Subject: Application for variation of conditions 2021/91239

406 Birkby road

Proposed Site Layout Plan

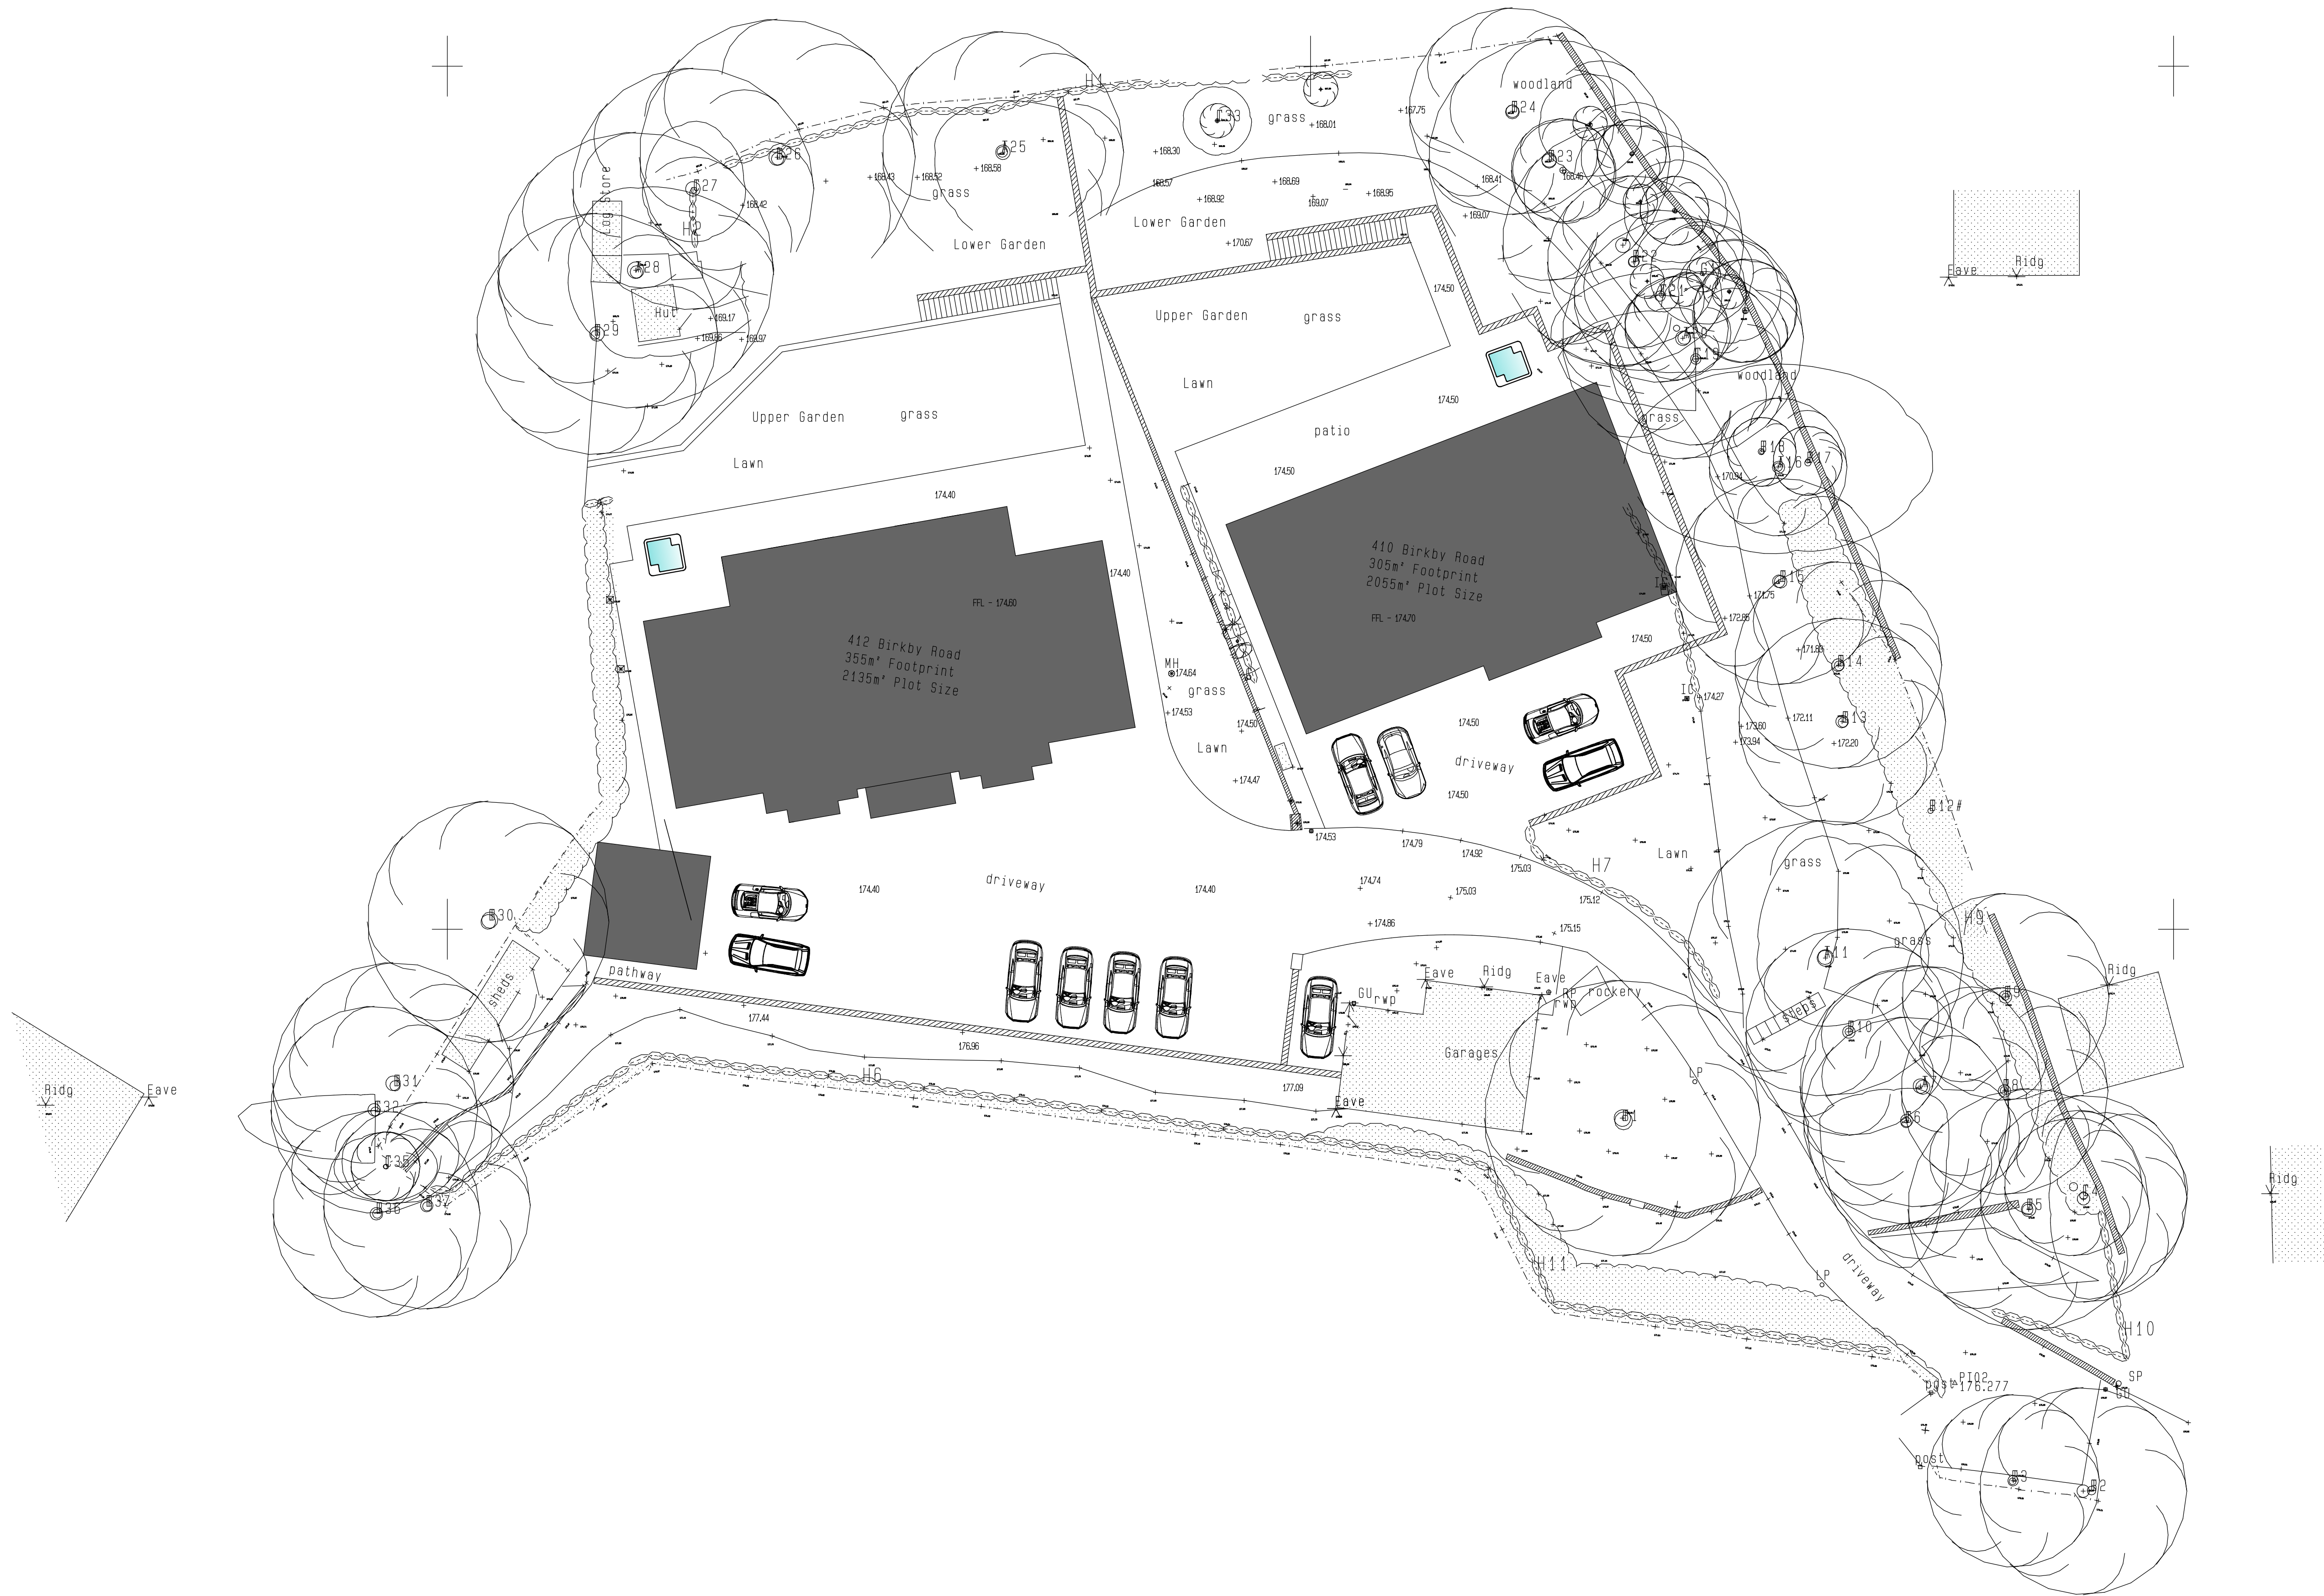
Puzzled why he refers to “a garage in the south eastern corner of the site” when the application is to re-site it in the south western corner of the site.
